CITY OF ALBUQUERQUE

PLANNING DEPARTMENT – Development Review Services

January 20, 2015

**RE: Anasazi Ridge, Unit 3
Drainage Report, and Grading and Drainage Plan
Engineer's Stamp Date 1-12-2015 (File: A10D002G)**

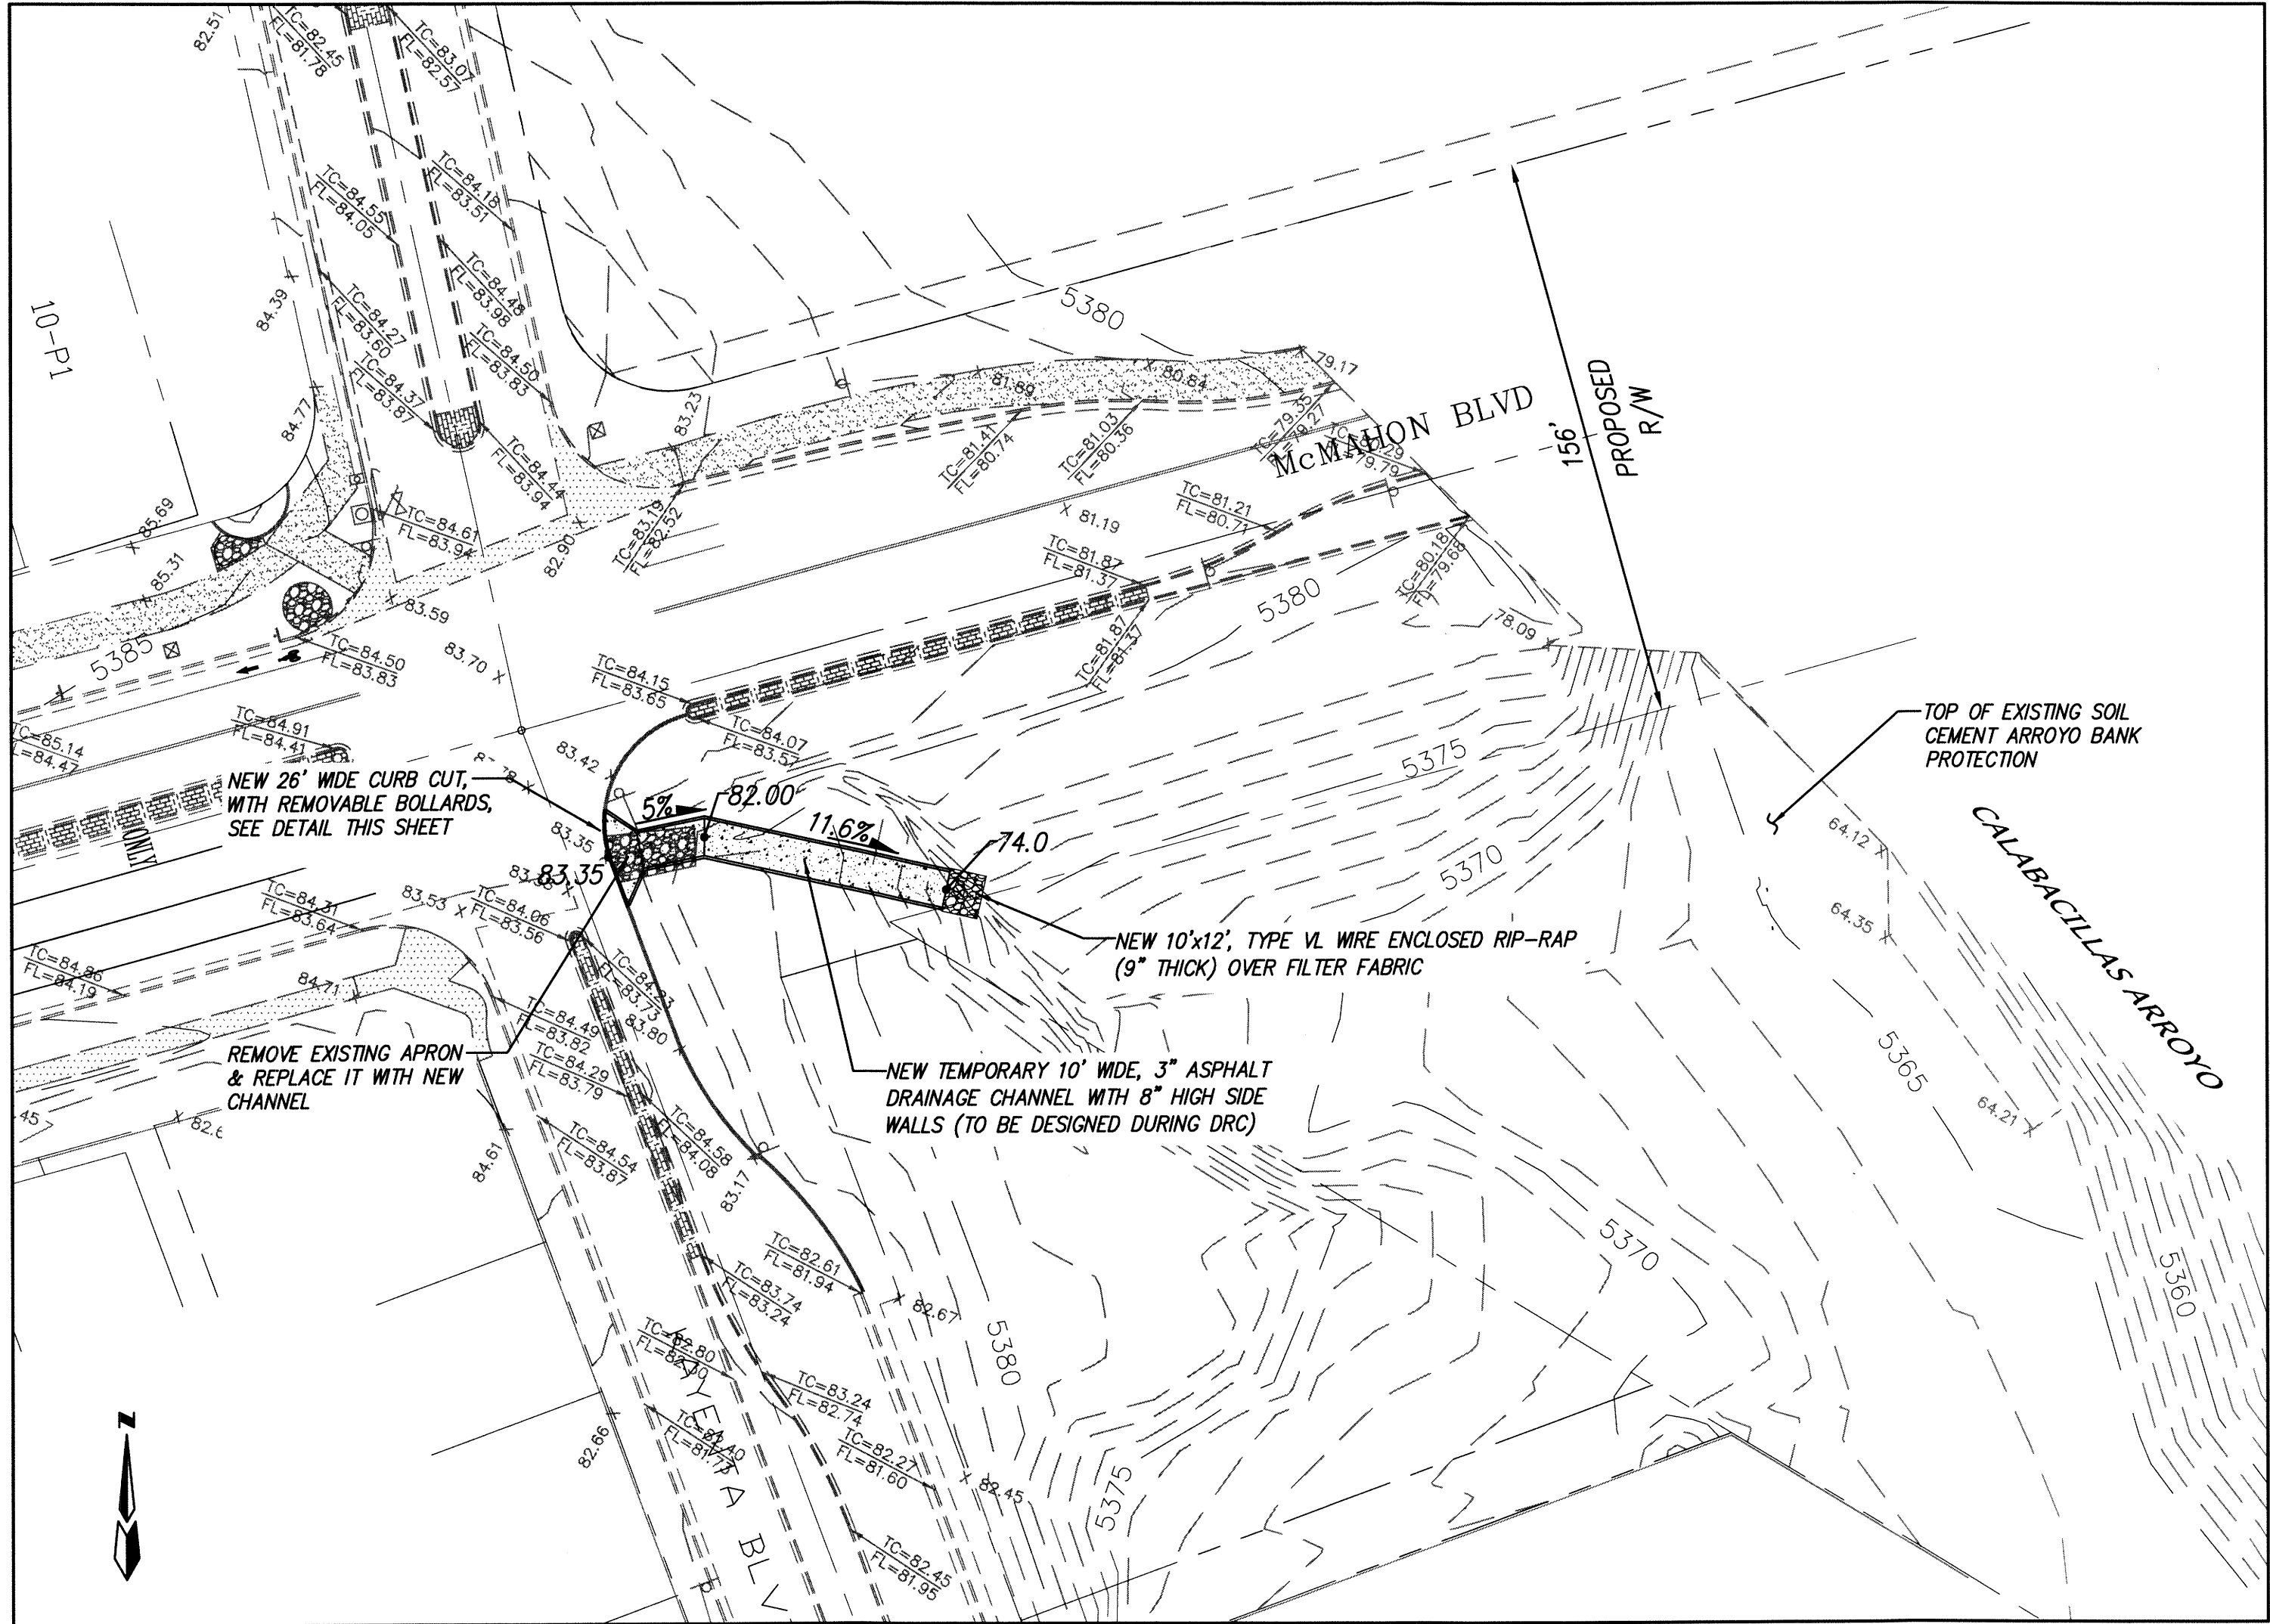
- a. Concrete spillway at Calle Vizcaya should be a rundown as opposed to a vertical drop.
